ENGINEER'S CERTIFICATION FOR STAPLES OFFICE SUPERSTORE, (F-21/ RE: D012), ENGINEER'S STAMP DATED 2/21/00, CERTIFICATION DATED 7/10/2000.

RE: STAPLES OFFICE SUPERSTORE - MONTGOMERY @ EUBANK (F21-D12).

GRADING AND DRAINAGE PLAN FOR BUILDING PERMIT AND SO#19

February 4, 2000

GRADING & DRAINAGE PLAN

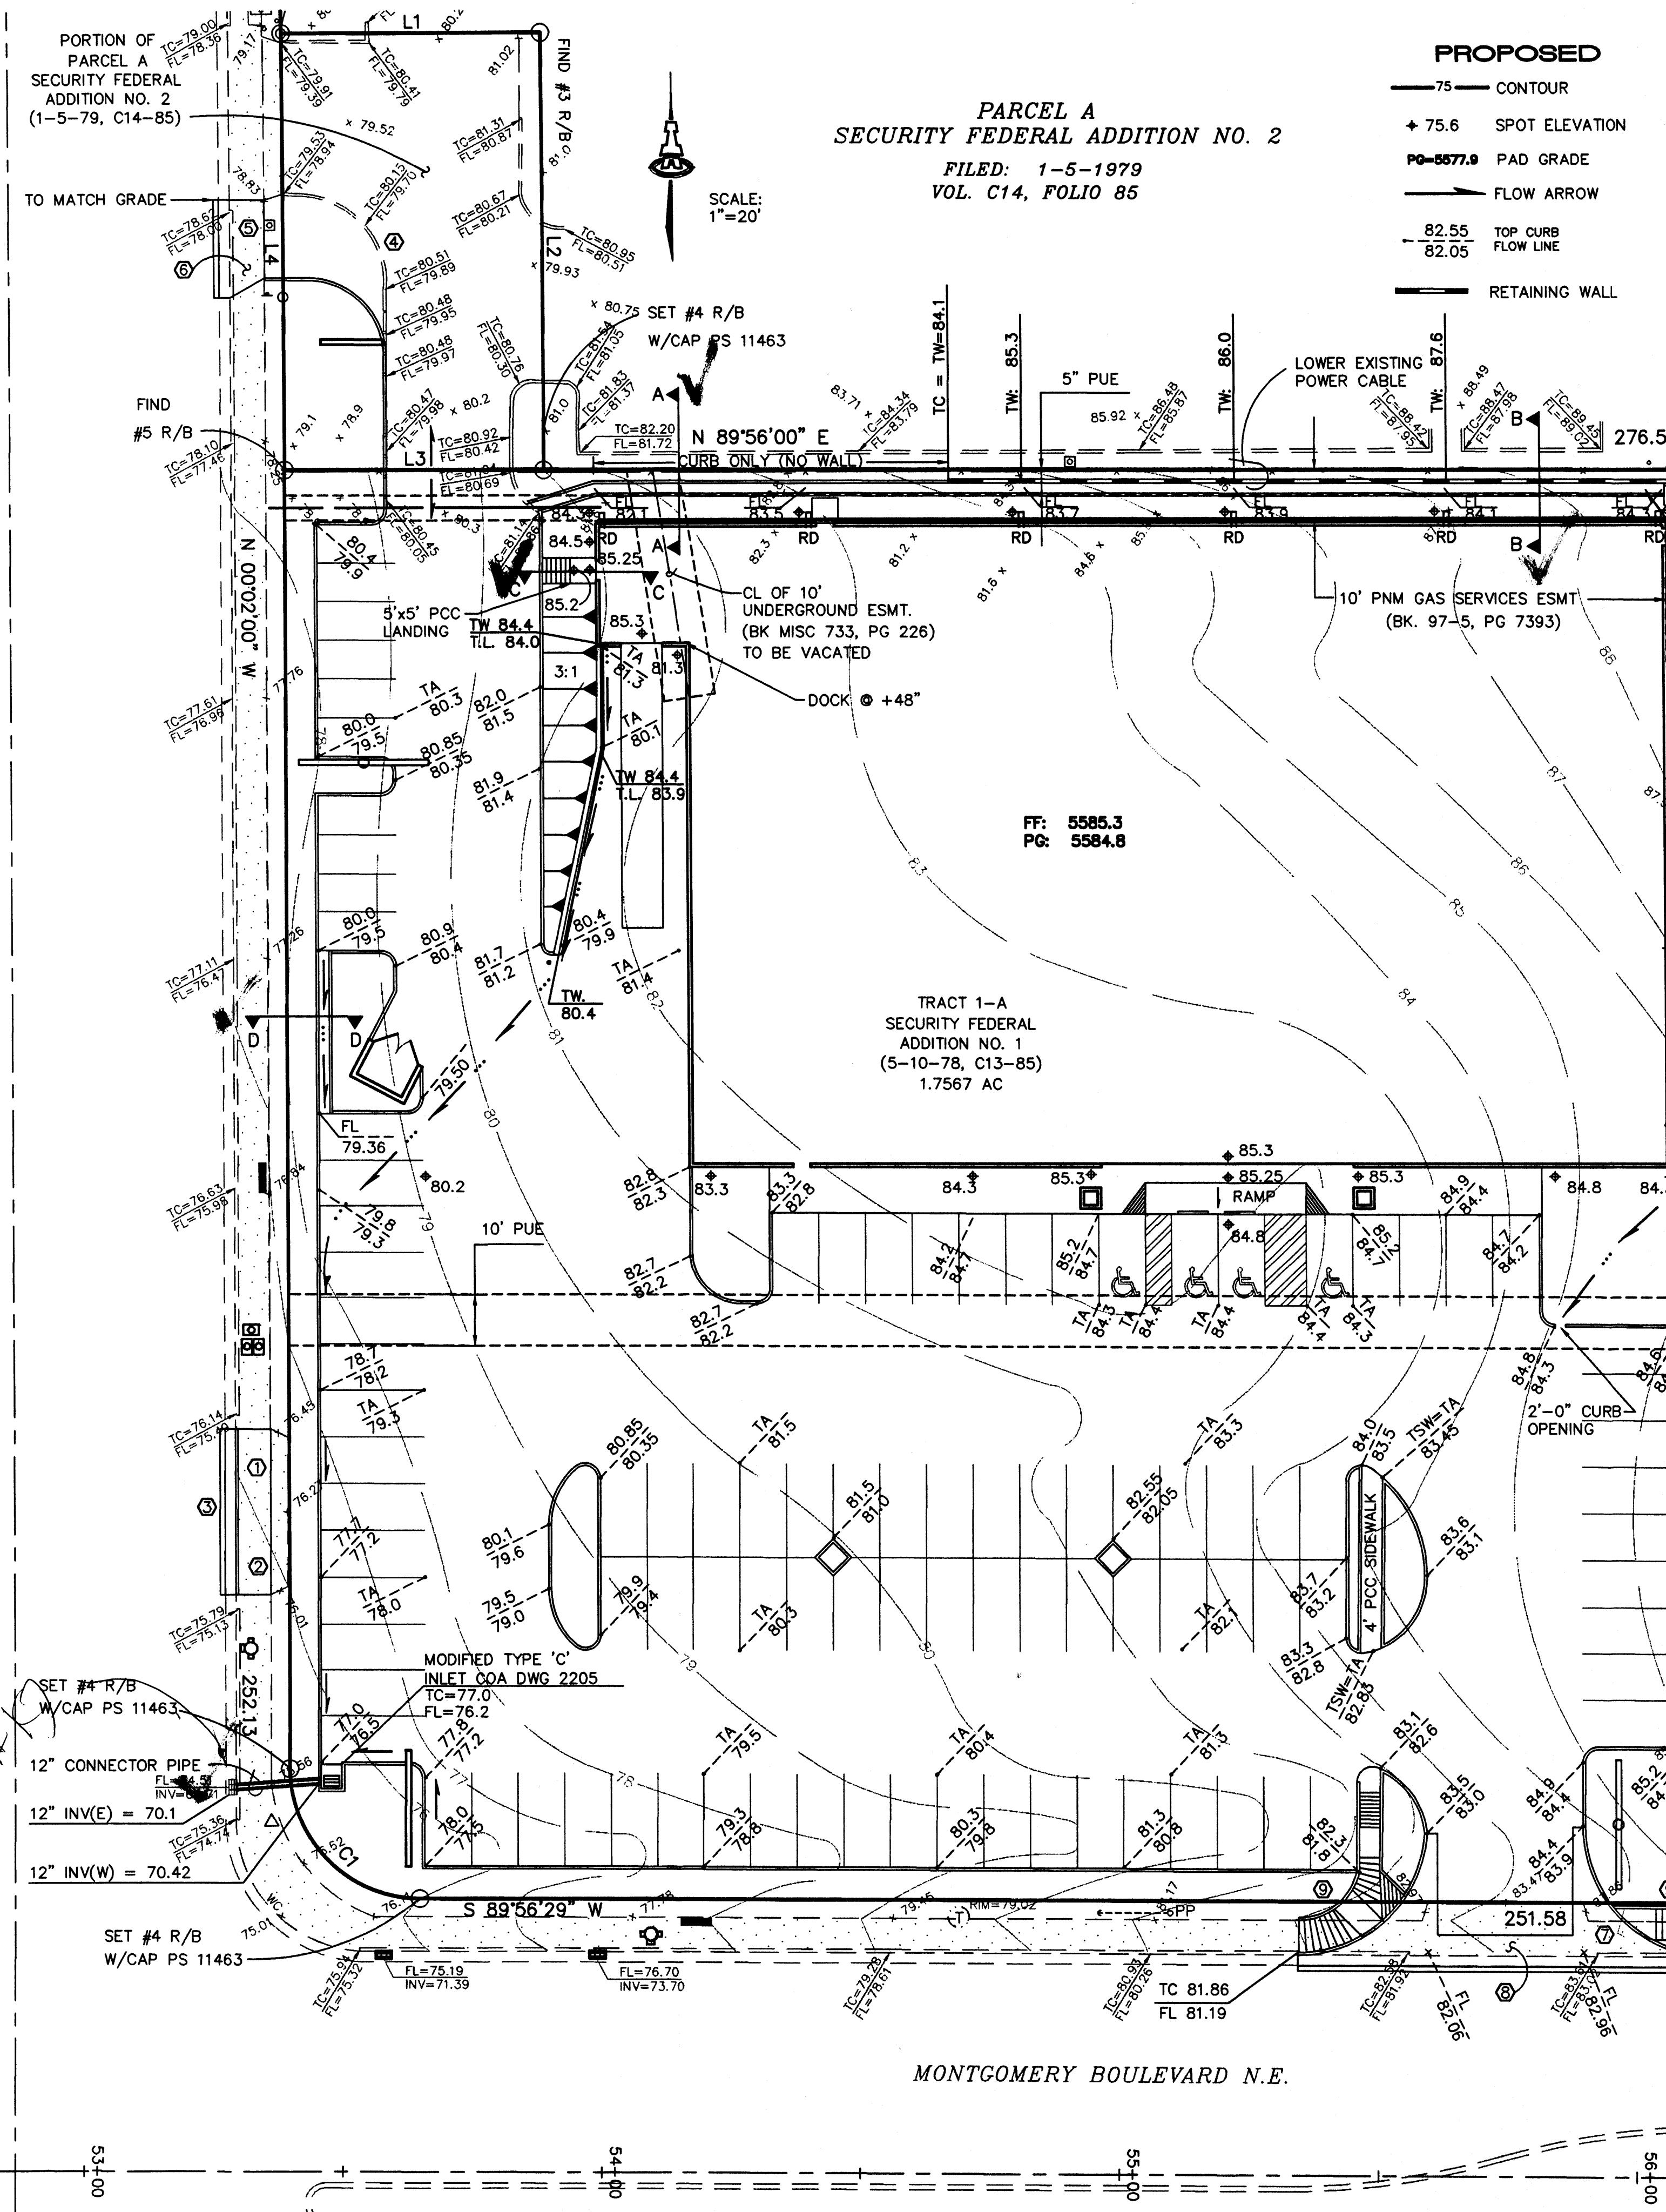
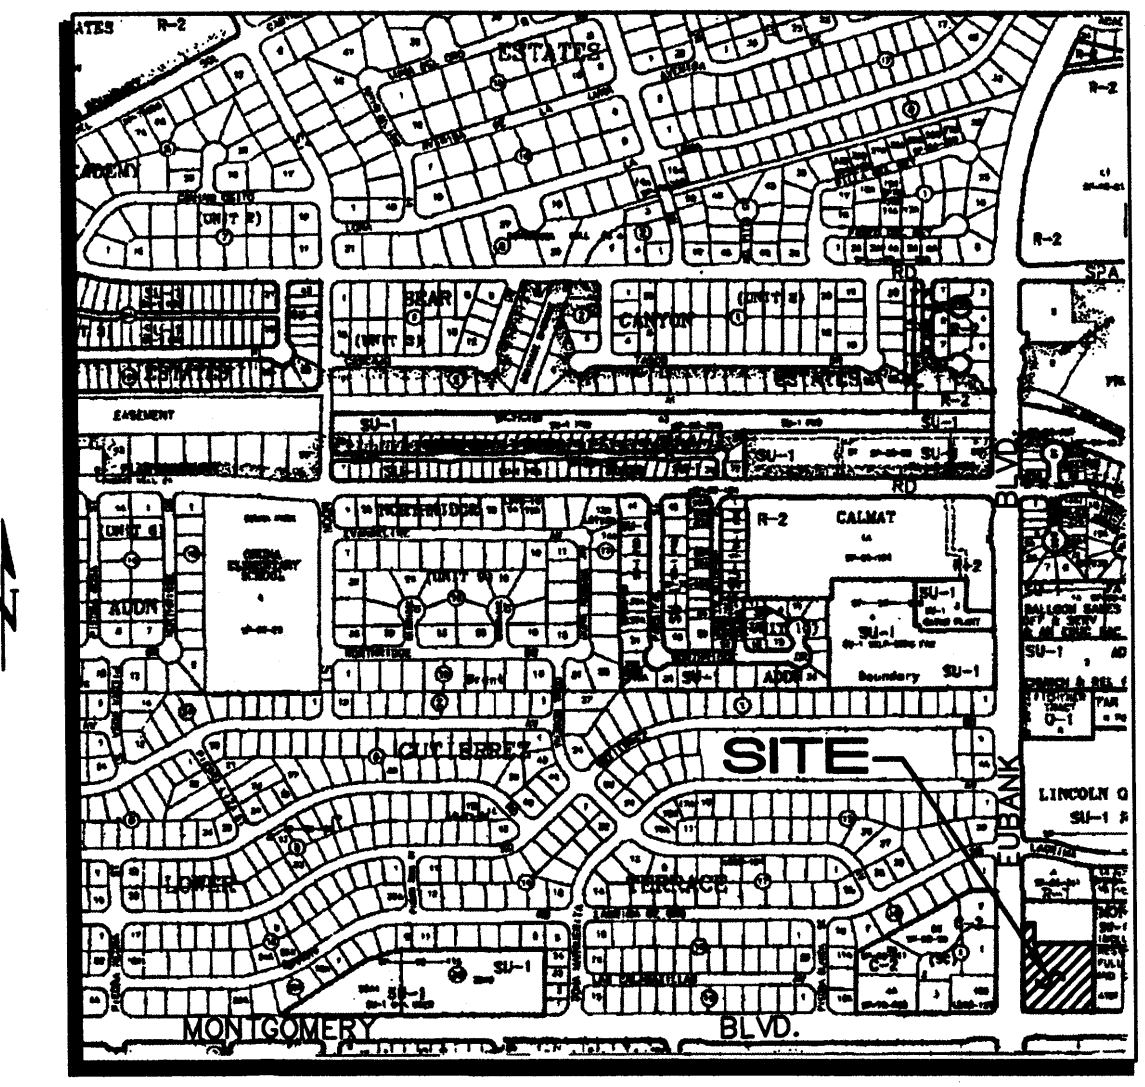
Add the standard SO#19 notes and signature block to cover the tie-in to the existing catch basin on Eubank Boulevard. Provide a second coppy of the G&D Plan for that process.

FIRM Panels 143 and 144 dated September 1996 are the correct references for the Flood Zone Designation.

East of Eubank and North of Montgomery is in Zone Atlas F-21.
